From: steve kus [REDACTED]
Sent: 24 May 2019 15:18
To: Planning.Responses
Subject: Re: Further Information Required on Your Ref: PP-07824424 Our Ref: BR/155/19/PL

Block Plan Amend
Please show the position of all windows being replaced.

The Mews, Mead Lane, Bognor Regis, PO22 8AL

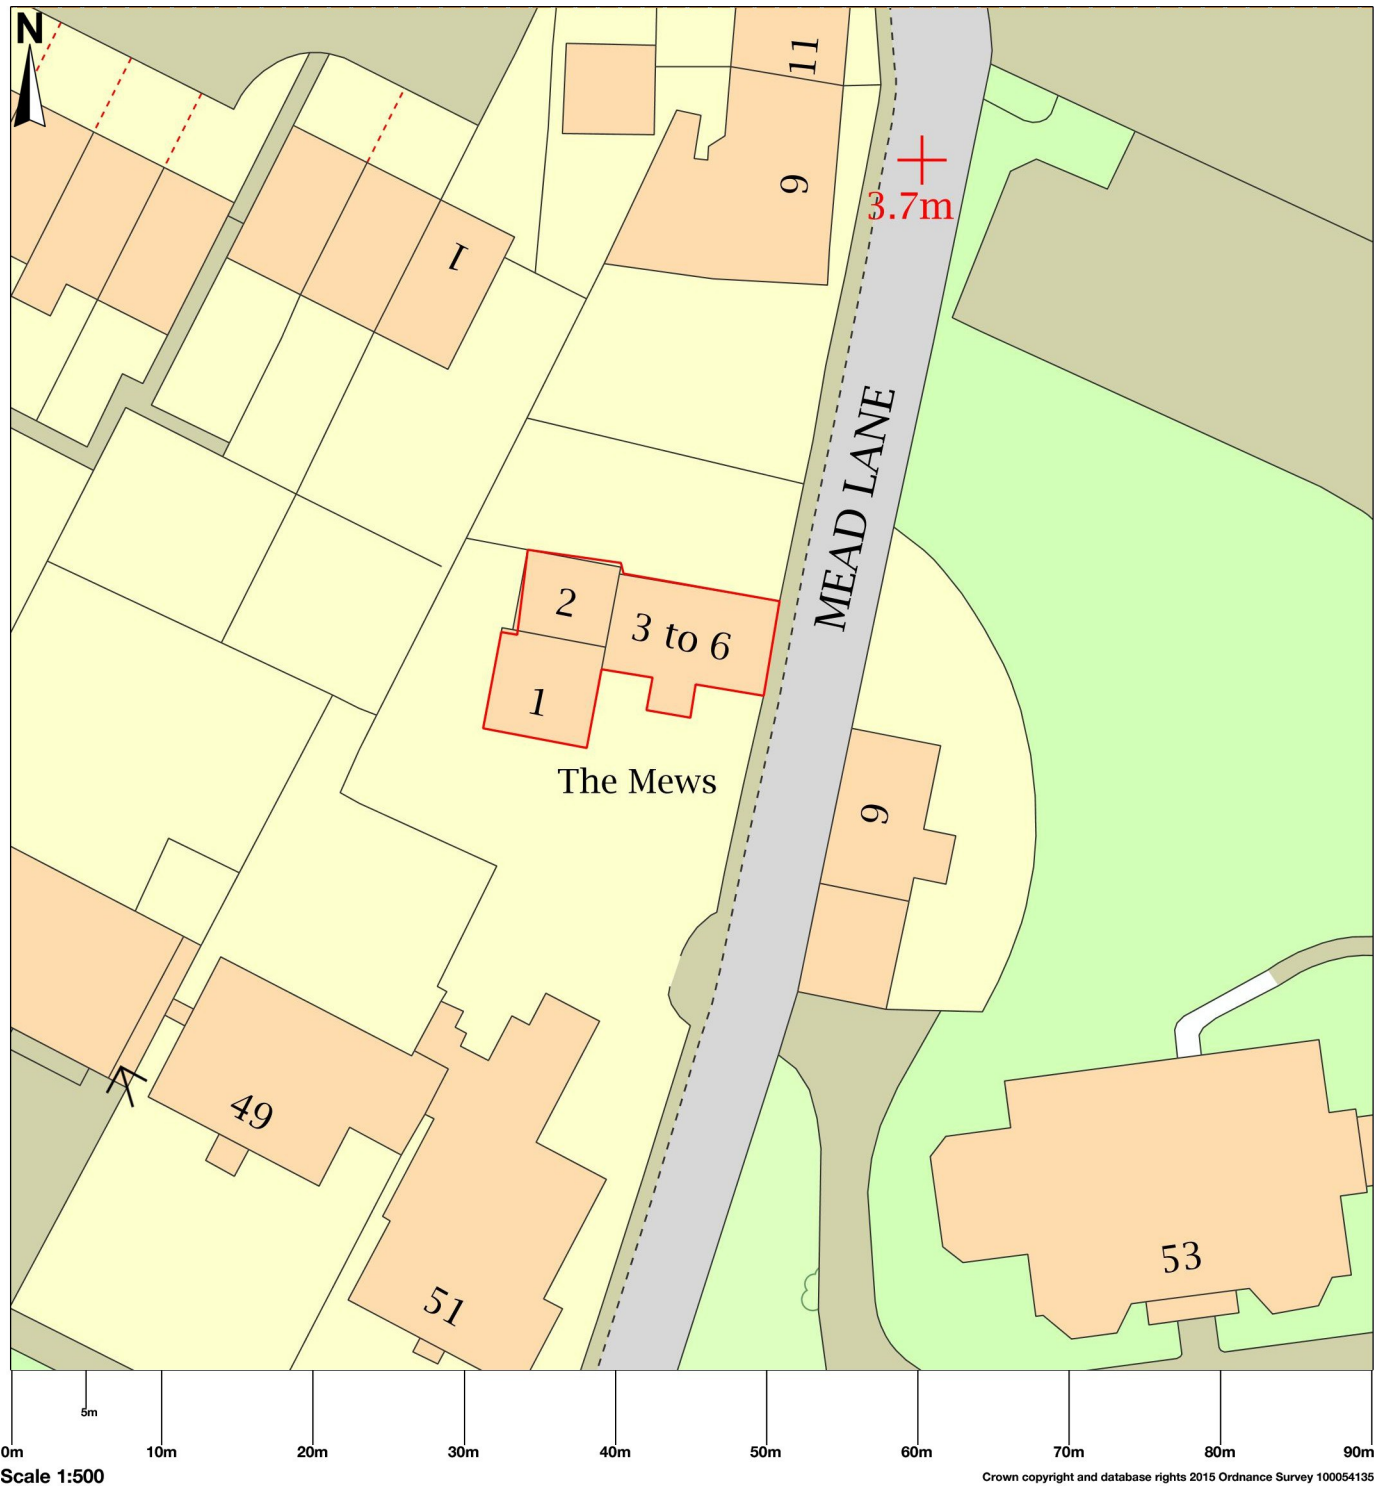
Please indicate if the windows are on both side elevations or only one.

*Please see attached amended block plan with additional detail and photographic supporting information.
Photographs have been provided for each elevation of the building along with a breakdown of windows by elevation.
Yellow dots have been placed under each window to be replaced.*

*The windows are on all side elevations, however on one side there is only one small window.
Please see amended block plan for full details of windows by elevation.*
